**CITY OF ALBUQUERQUE  
PLANNING DEPARTMENT  
January 25, 2012  
DRB Comments**

**PROJECT # 1004034                      APPLICATION # 12-70015**

**RE: Tract A, Brentwood Hills Subdivision**

CLIENT: SW JUAN TABO, LLC CITY: ALBUQUERQUE N.M.  
**PLAT OF TRACTS A-1, A-2, & A 3**  
**BRENTWOOD HILLS SUBDIVISION**  
**CITY OF ALBUQUERQUE, NM**

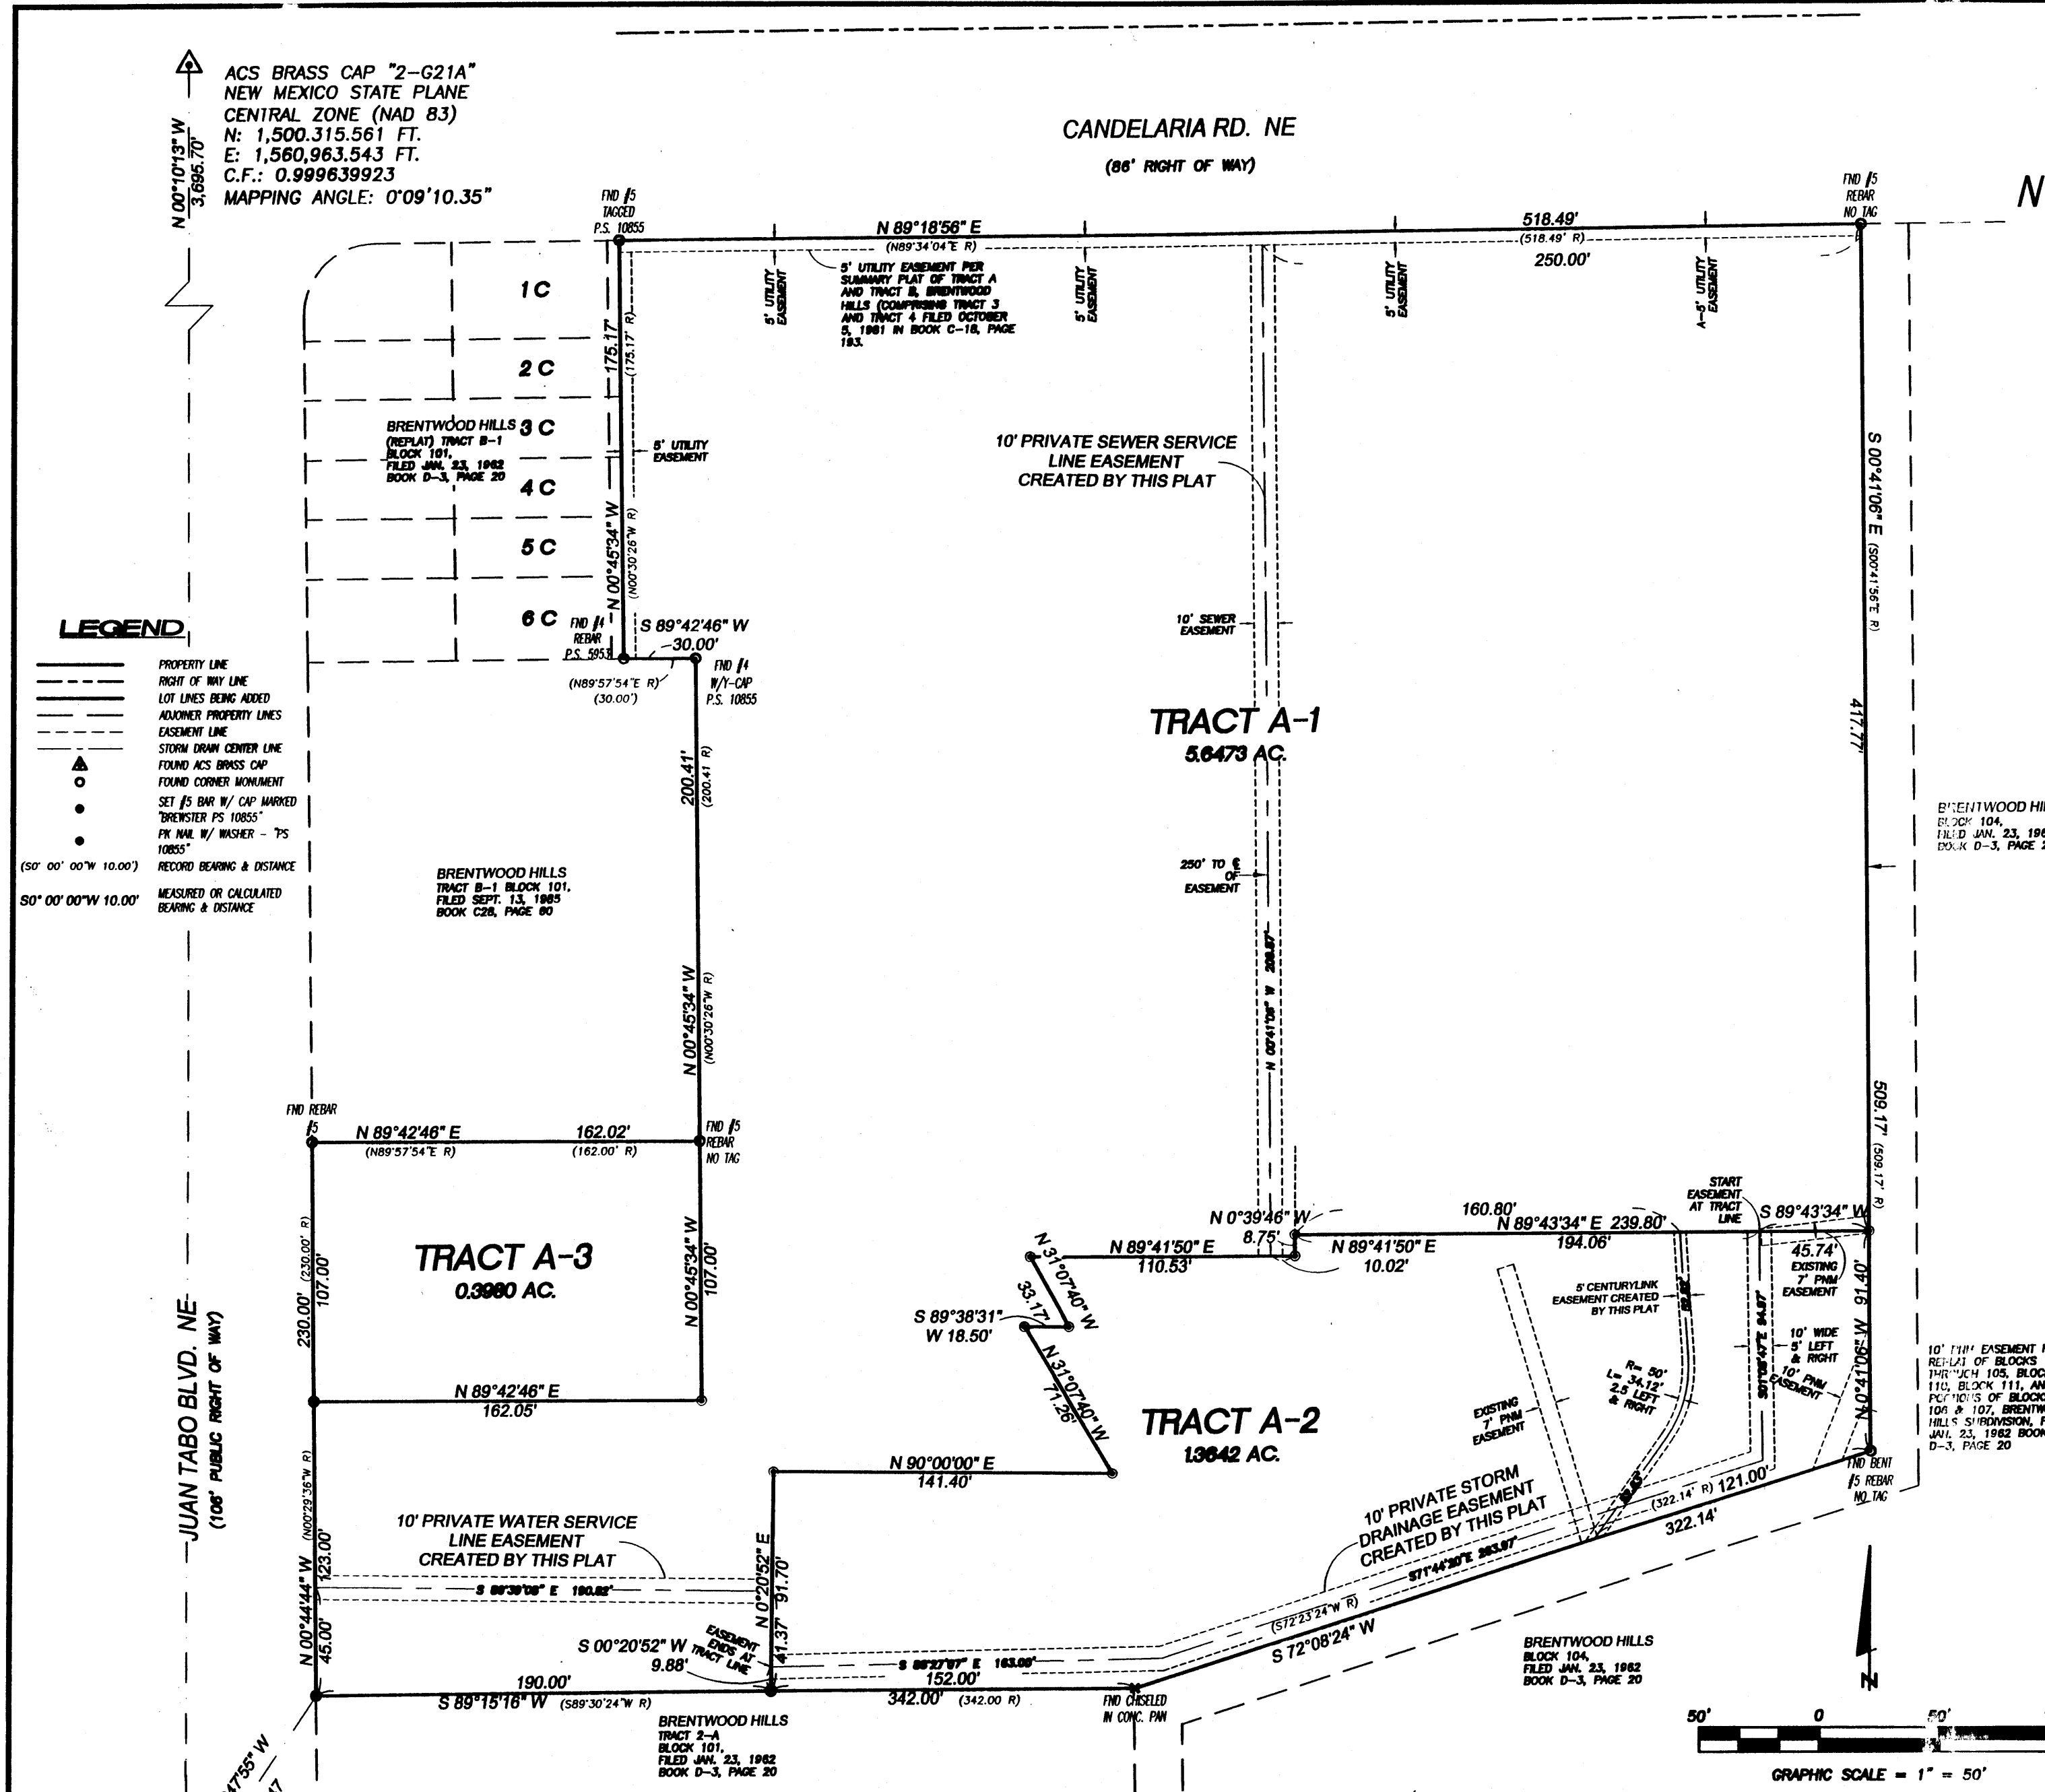
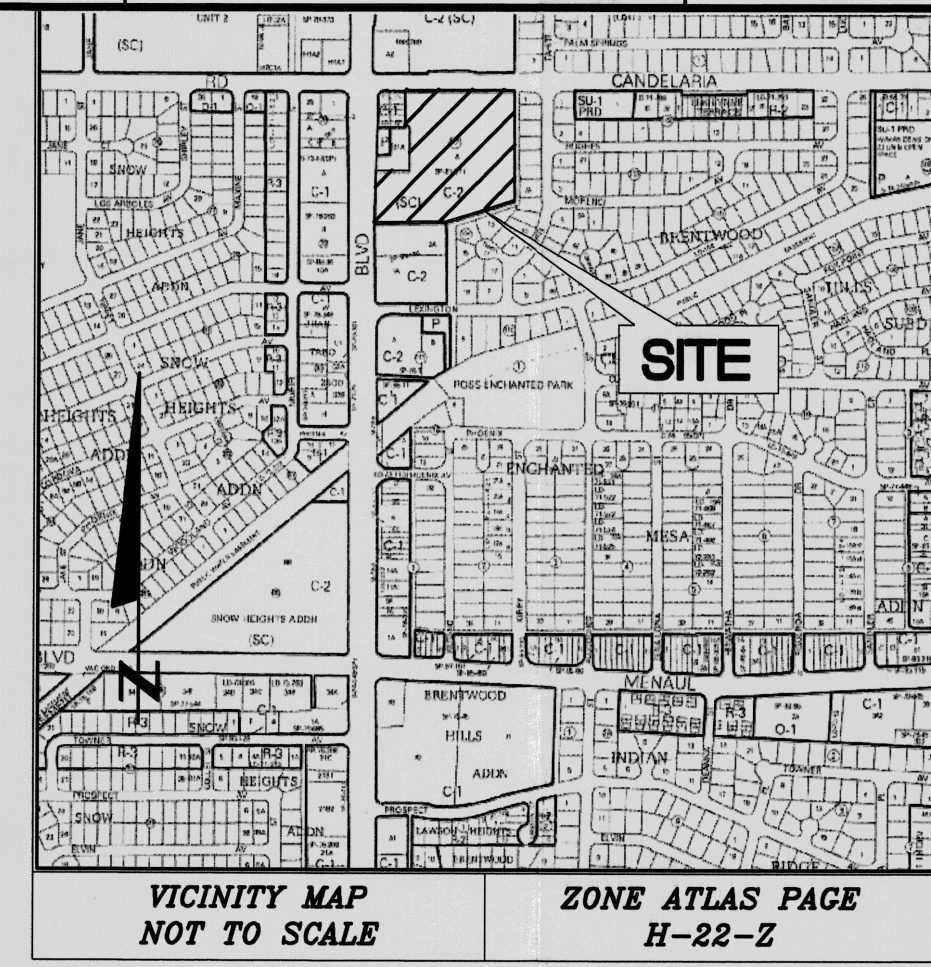
Maintenance as well as Beneficiaries of easements must be clearly noted on plat; plat needs to show all easements of record.

A Solar Note is needed in compliance with § 14-14-4-7 (B); replace the words “requested final action” with “this plat” at the beginning of the note, and delete the words “or site development plan for subdivision” at the end of the note.
